**RE: 130 Eastern Promenade
Level 2 Site Plan Amendment
Response to Staff Review**

Project Memo: 130 Eastern Promenade

RE: Response to Staff Comments

L-2.0

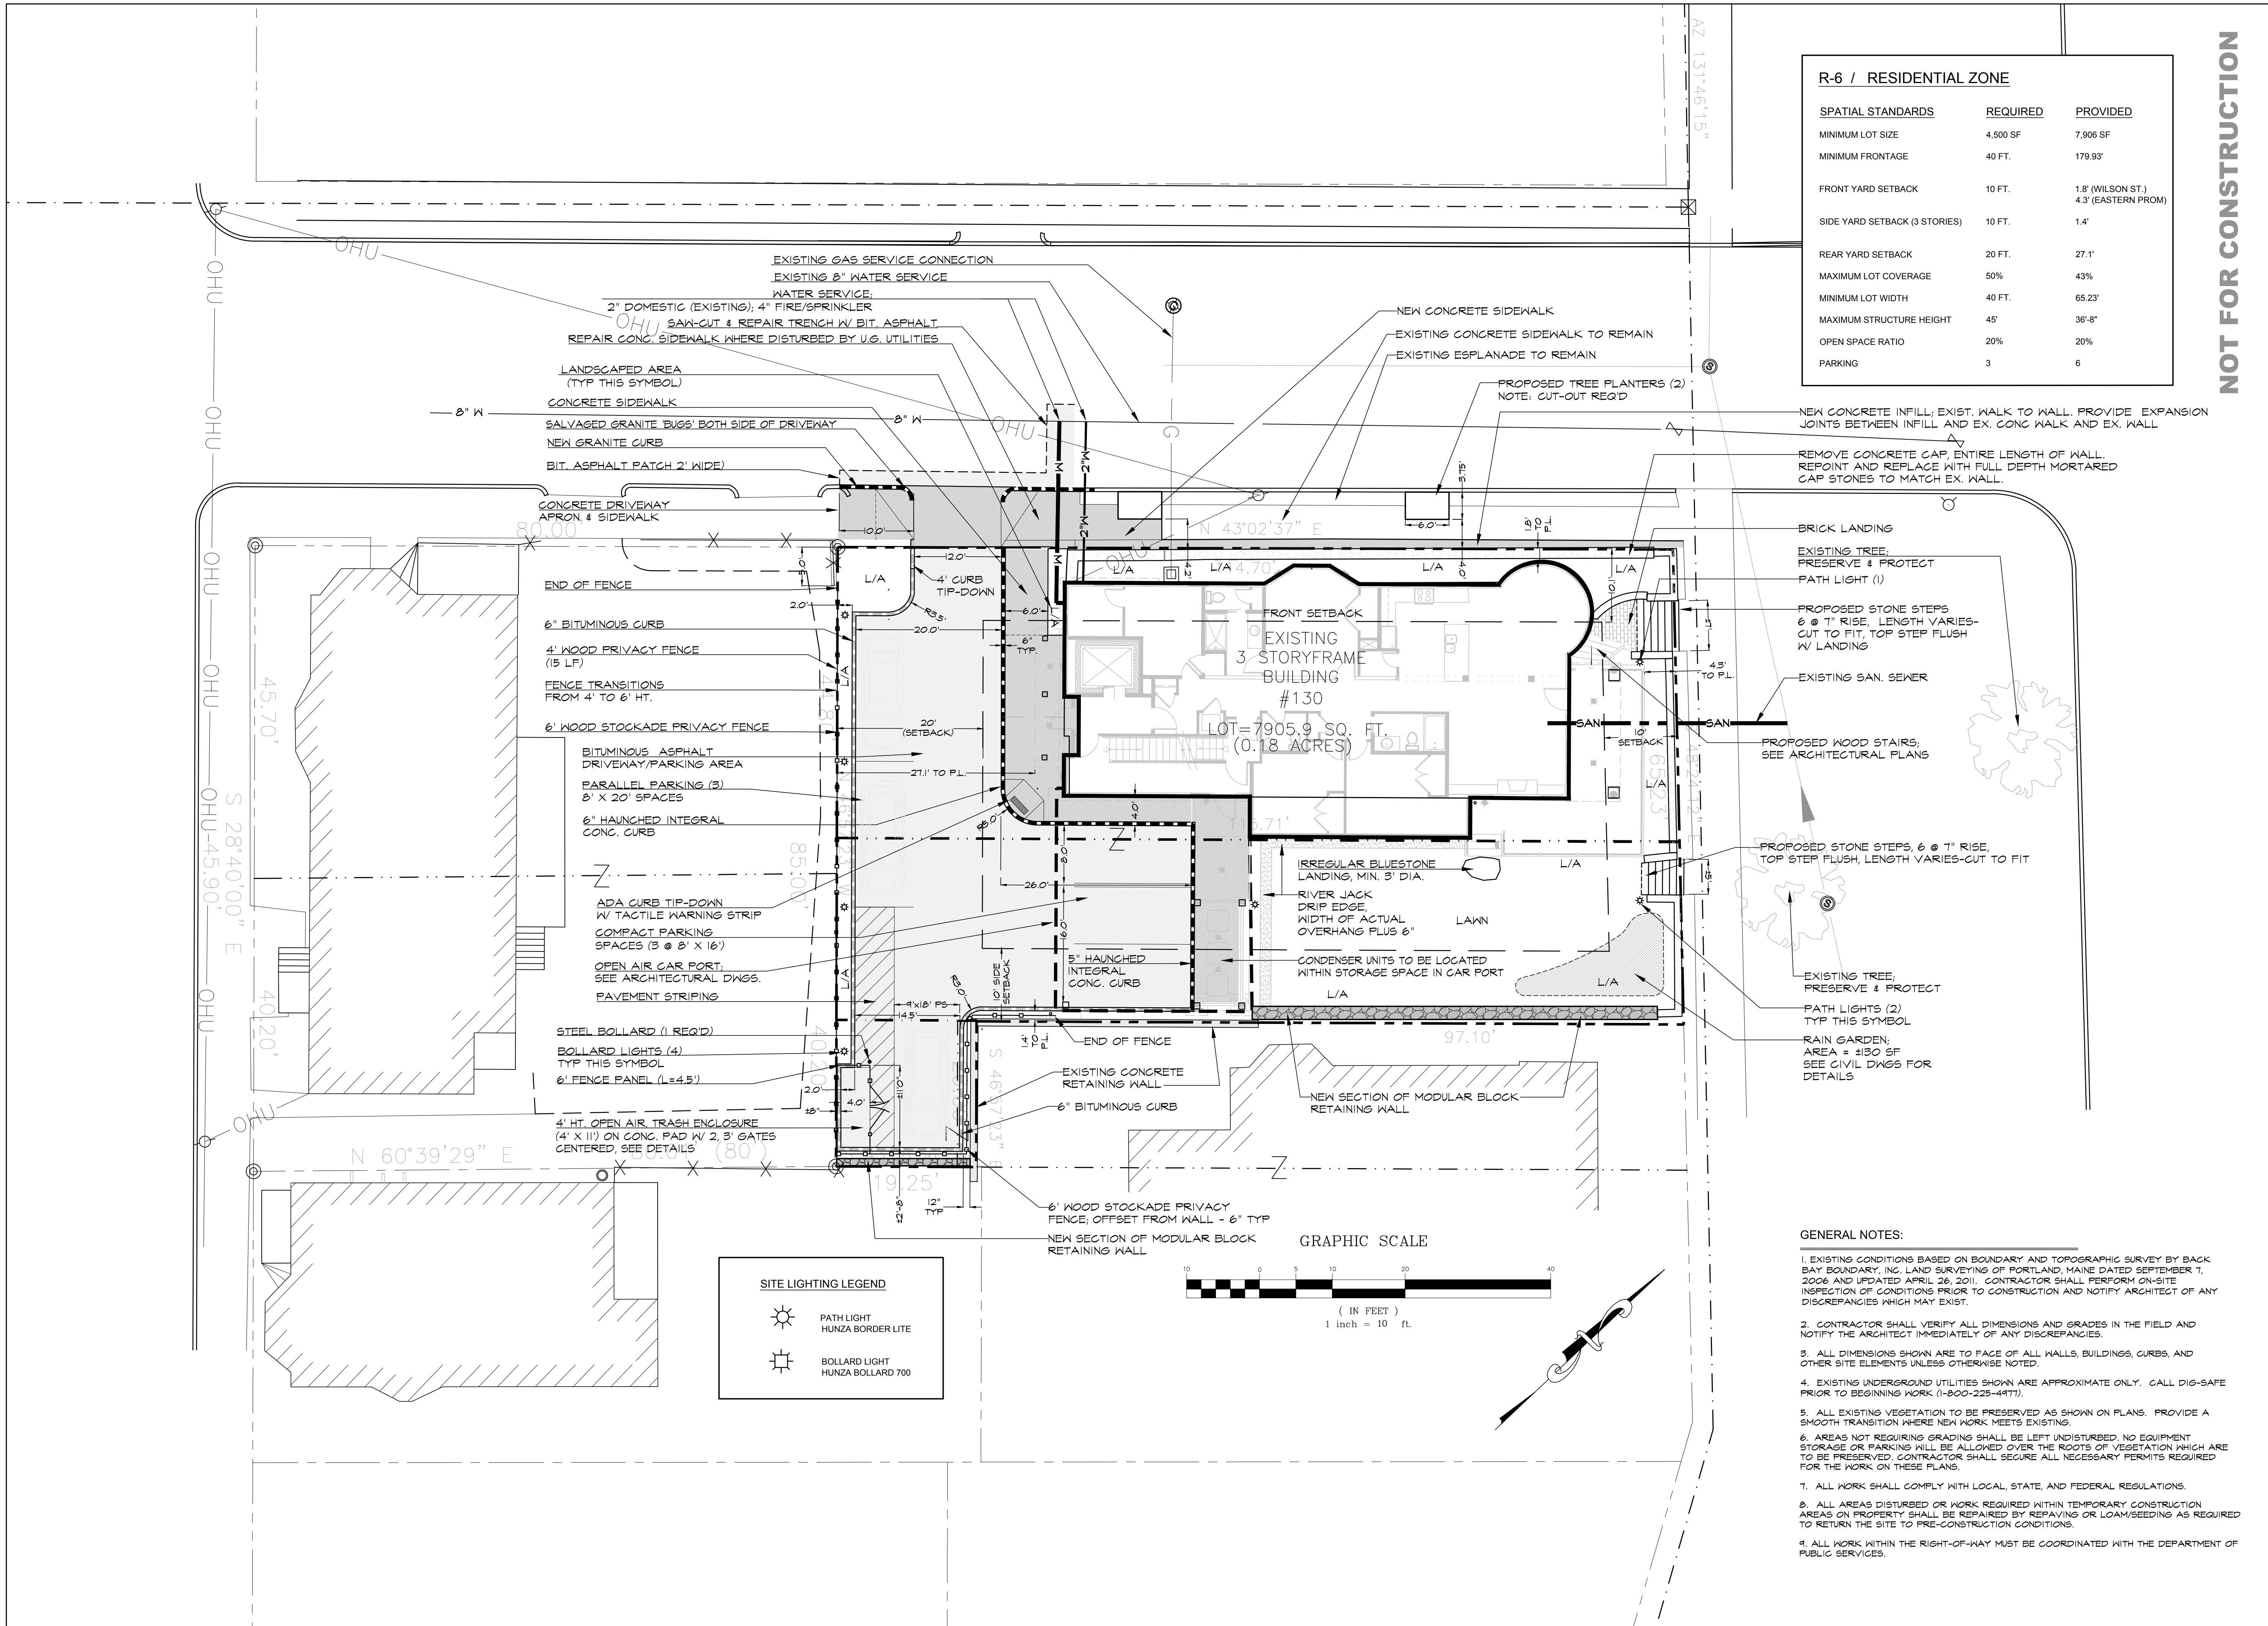
To stay in character with the neighborhood, the applicant is requested to reuse the granite curb "Bugs" to define the driveway cut and not granite tip-downs as proposed.

Please score a defined joint between the proposed concrete walk infill and the existing concrete walk.

Please extend the proposed tree planter cut out to 3.75' wide from inside face of curb to be consistent with cut outs up the street.

Response: The existing granite bugs will be salvaged and reused to define the new driveway. The plans and details have been revised to reflect this request.

Response: Expansion joints will be installed between the existing concrete sidewalk and the proposed infill, as well as between the proposed infill and the existing retaining wall. A note stating this has been added to the plans.

Response: As requested, we have revised the plans to show the tree pit cut outs at 3.75' x 6'. This will provide a minimum of 4'-0" of sidewalk clearance between the tree pit and the existing stone wall for universal access.

L-4.0

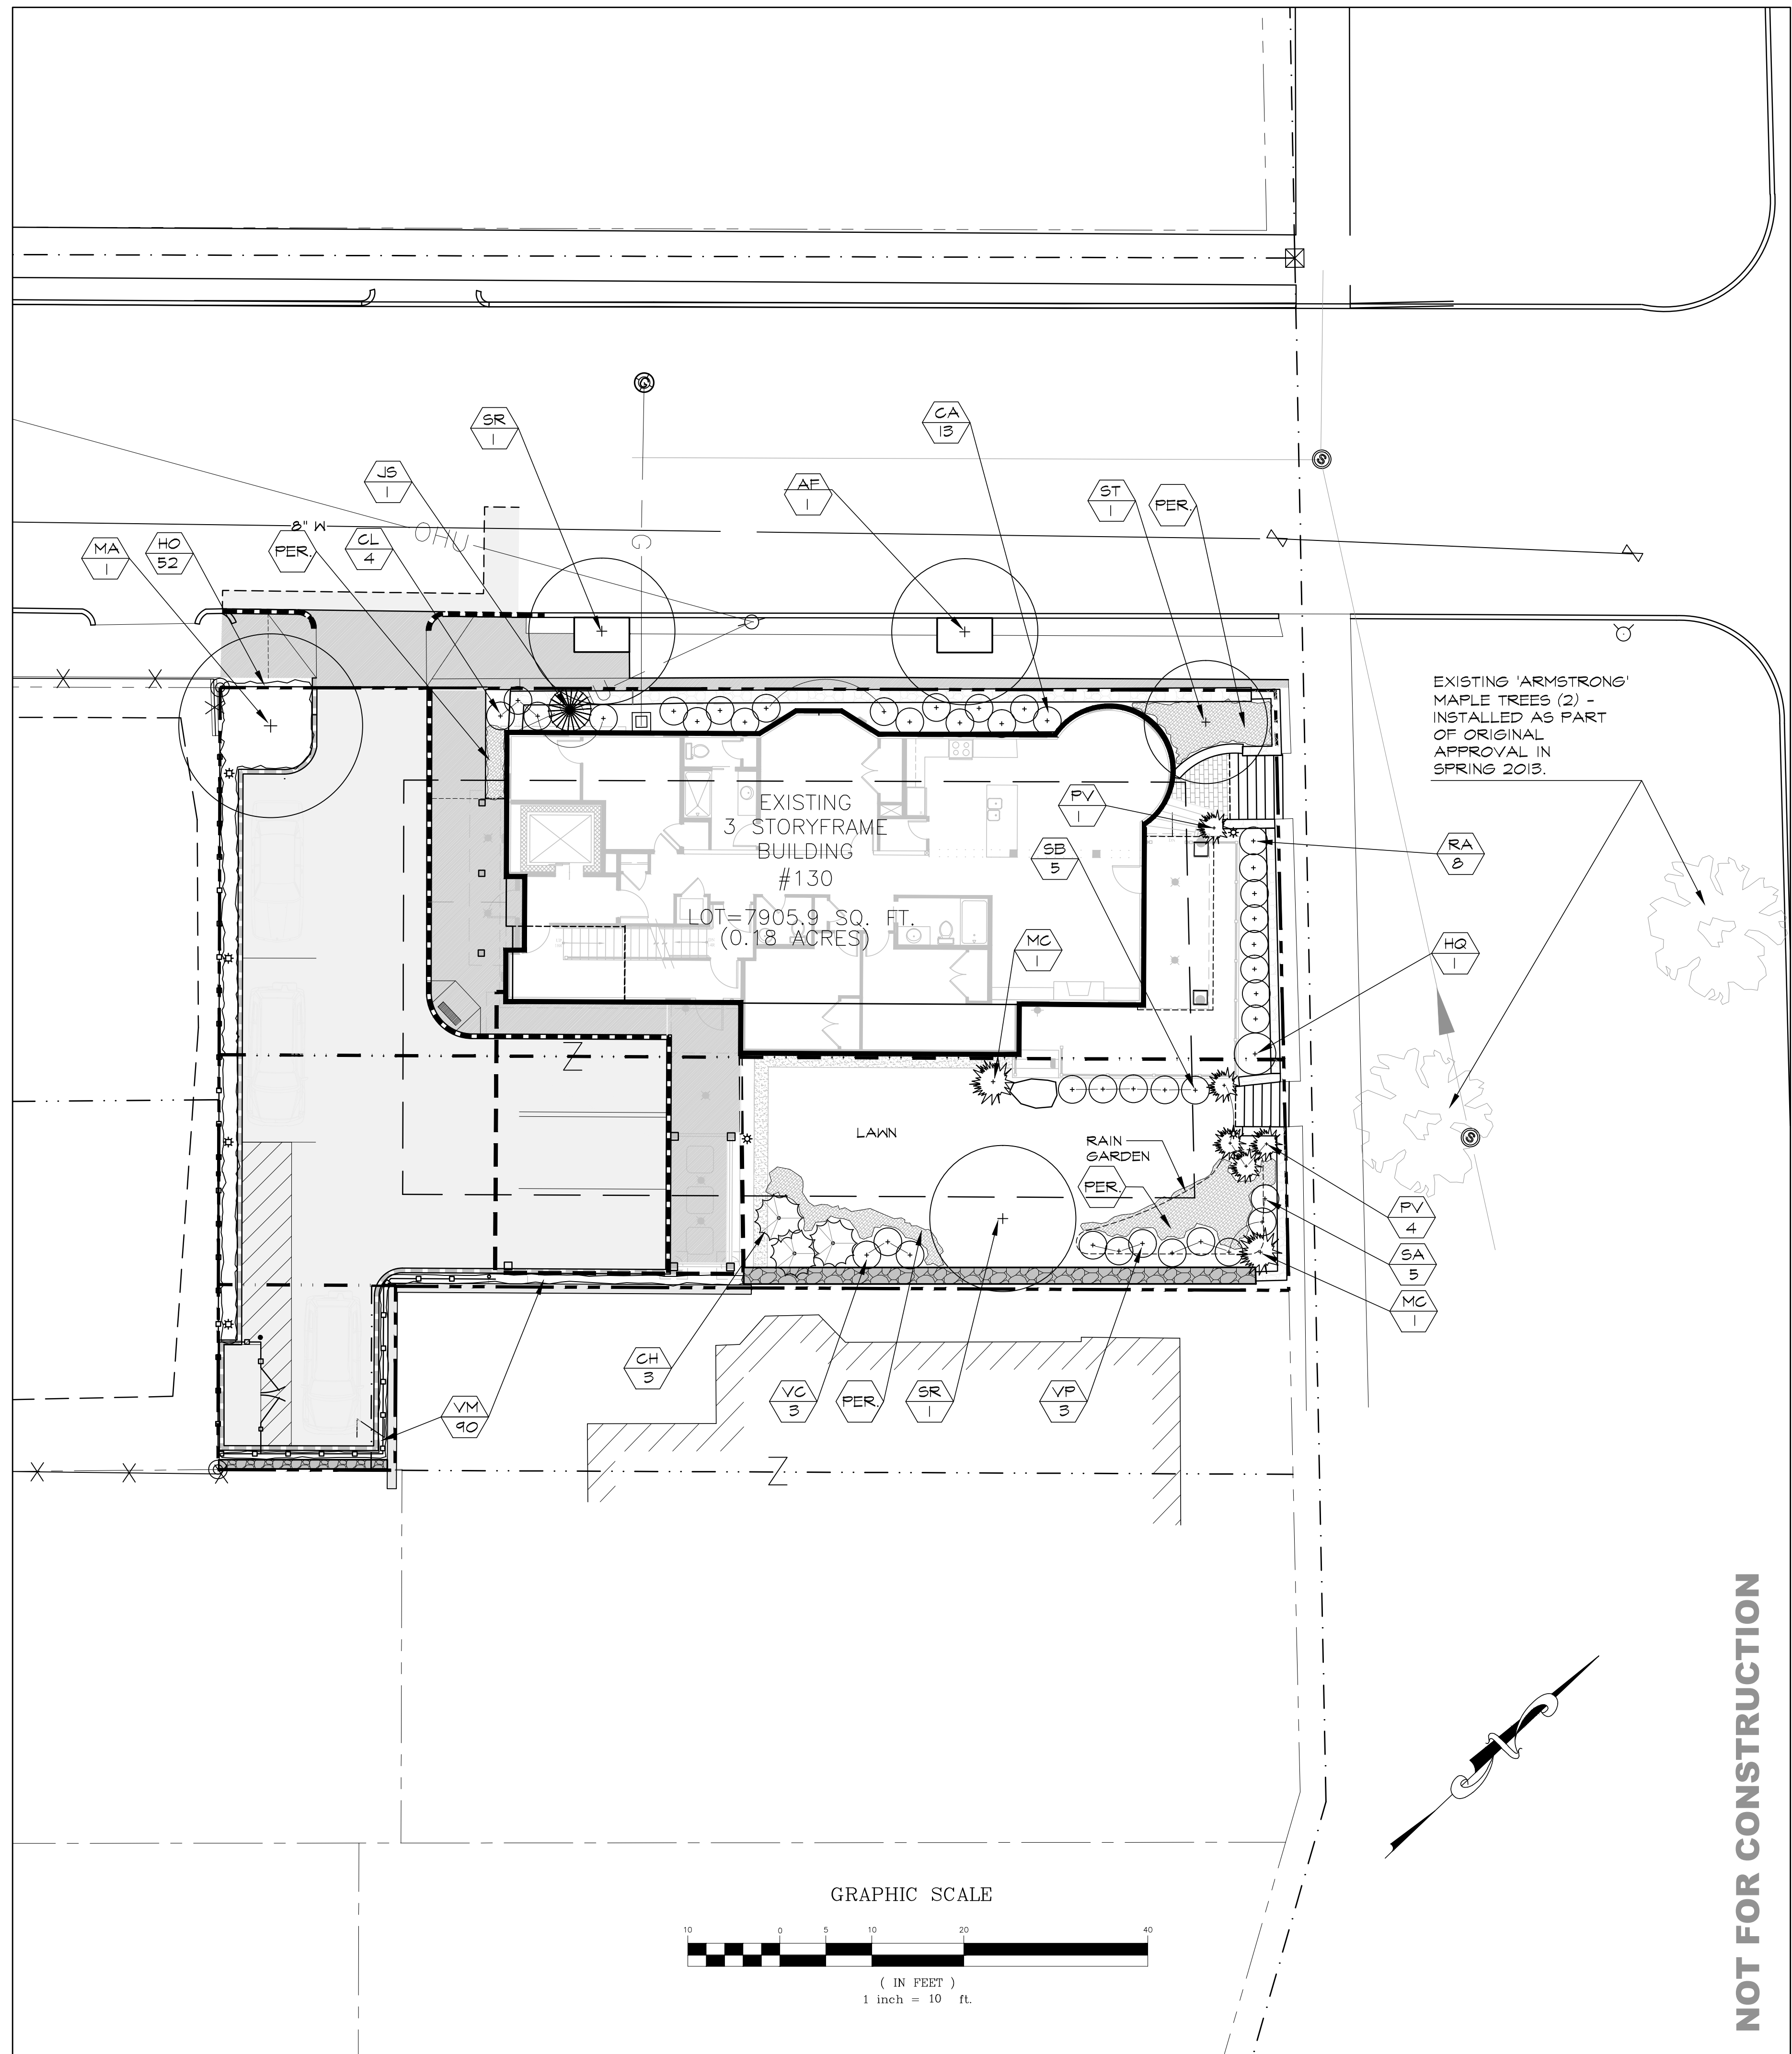
The project proposes two new street trees along Wilson Street. Due to overhead utility lines overhead on the second tree (away from E Prom) that tree should be a smaller tree such as Sargent Cherry, Japanese Tree Lilac vs. the 'Armstrong' Red Maple as shown. The maple is good for the tree closest the prom with no overhead wires.

Review and increase plant sizes for the 1 gallon plant sizes to 3 gallon size on 'Gro-Low' sumac, the crab-apple recommendation would be "Adirondack". Options for the proposed Japanese Tree Lilac could also be dogwood or crab-apple.

Response: The selection of the second street tree back from the Eastern Promenade has been changed to a Japanese Tree Lilac so not to interfere with the overhead utility lines as it matures. The selection of the cultivar called "Ivory Silk" will eventually obtain a mature canopy size of 18-20' tall and 12-15' wide.

Response: The plant schedule has been revised to specify the proposed size of the 'Gro-Low' Sumac has been increased to a 3 gallon pot and the cultivar of ornamental crabapple has been specified as 'Adirondack'.

4 CONC. MODULAR BLOCK RETAINING WALL DETAIL
NOT TO SCALE

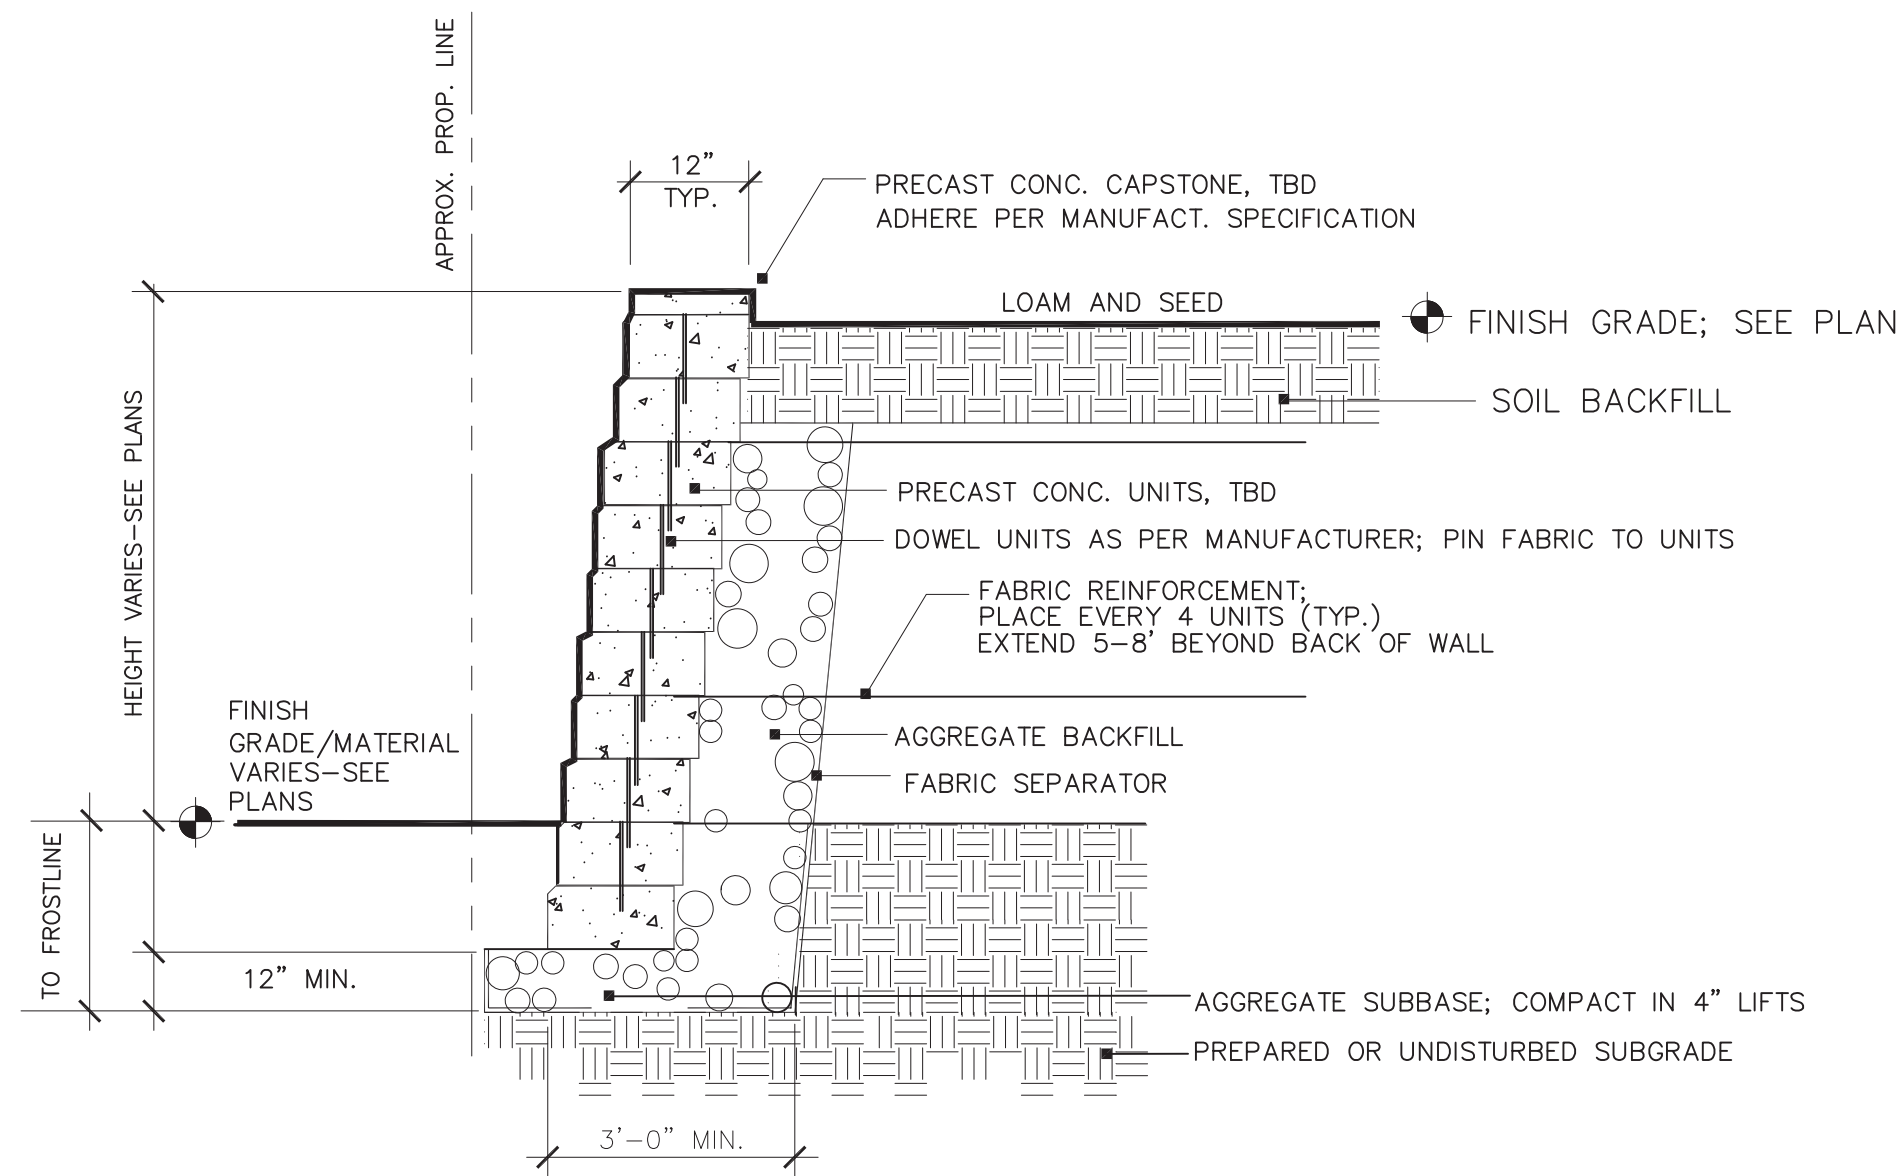
The rain garden details on sheet D-1.0 and the retaining wall detail on L-5.1 indicate that an underdrain will exist below the rain garden and at the base of the retaining wall; however, no underdrains are depicted on the site plans. If an underdrain is required for these systems, we encourage day-lighting the underdrain(s) in lieu of a direct connection to the combined sewer; clarification should be provided on the plans and/or details.

Response: The retaining wall detail has been revised as it was determined that the underdrain at the base of the wall could be eliminated. Please refer to the attached letter, dated November 21, 2013, from Blais Civil Engineers for additional responses to the review comments.
